## Technical Memo

**To:** DSEL – Adam Fobert, P.Eng  
**Copy To:** File  
**From:** Lino Belgiorgio, P.Eng  
**Approved:** Peter Rüsçh, P.Eng  
**Date:** December 11, 2012  
**Subject:** Caivan – Richmond: Proposed Sump Pump Detail

SUMP PUMP - DETAIL

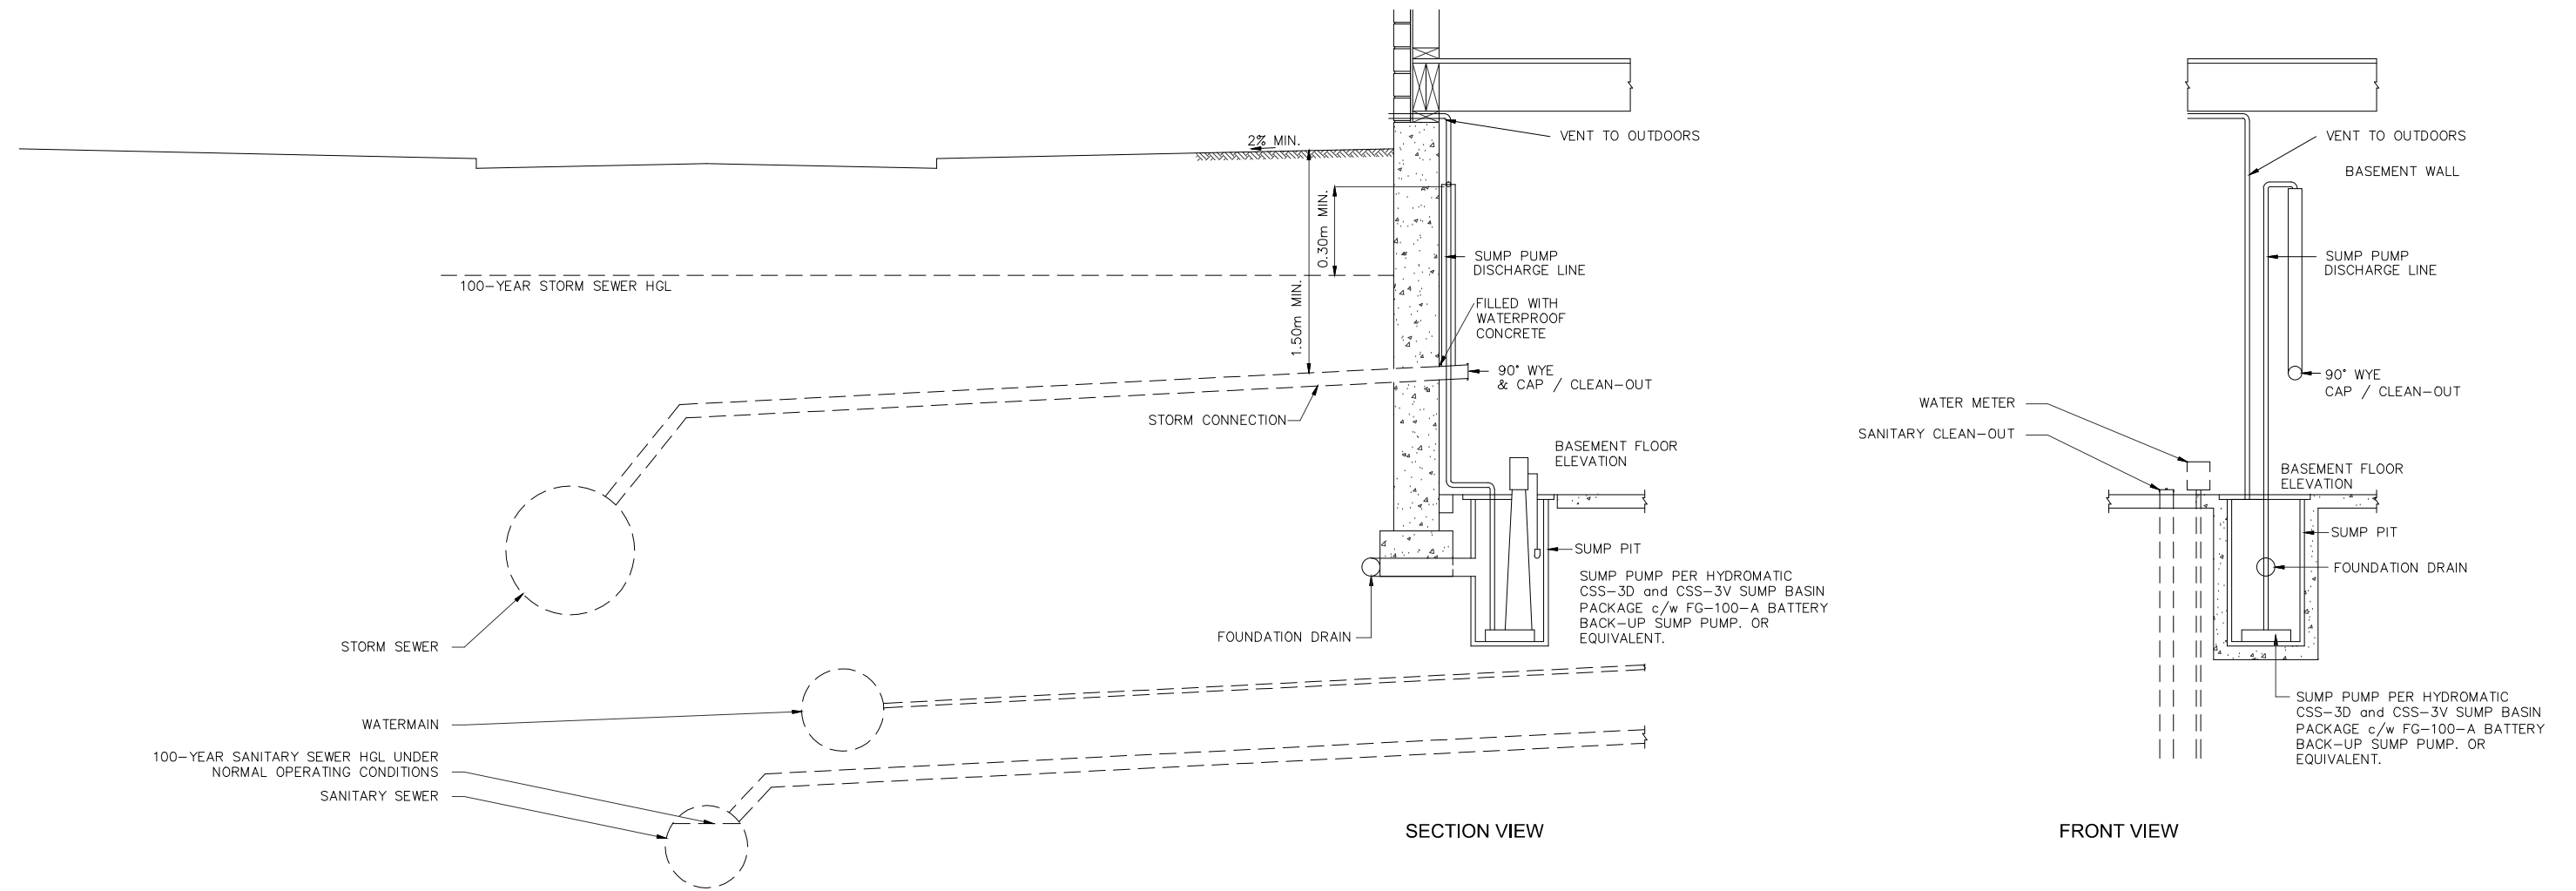
The proposed elevations are such that the discharge of the foundation drain via gravity to a culvert or a storm water drainage system is not possible.

The use of a sump pump located below the dwelling's basement floor, is proposed for the collection and discharge of the foundation drain flows.

We understand that soil conditions do not permit the discharge of the sump pump flows to the exterior ground surface or to a dry well system.

Consequently, the proposal is to discharge the sump pump flows to the storm drainage sewer via a 100 mm sewer pipe, extending from just inside the basement wall to the municipality's storm water sewer.

The 100 mm sewer pipe would terminate inside the basement with a 100 mm Y. The Y's straight leg would have a [screwed] cap for use as a cleanout.

The sump pump discharge will be connected to the Y's 45° leg and consist of 40 or 50 mm dia. pipe with a check valve, isolation valve and union.

The sump pump discharge would rise some 300 mm above the 100 year HGL before turning down and connecting to the sewer termination. Use of a backwater valve ahead of the 100 mm Y, is not considered necessary as potential backflow would be inhibited by the rise of the pump discharge elevation coupled with the sump pump check valve. The sump pump vent would terminate at the exterior of the dwelling.

Given that the pump discharge will be from a 40 or 50 mm pipe to a 100 mm pipe, there will be a free air surface at the junction of the Y connection, therefore siphoning will not be an issue. Provided a pump has been selected to operate within the preferred operating range [fairly close to best efficiency point], the sump pump arrangement will work as intended.
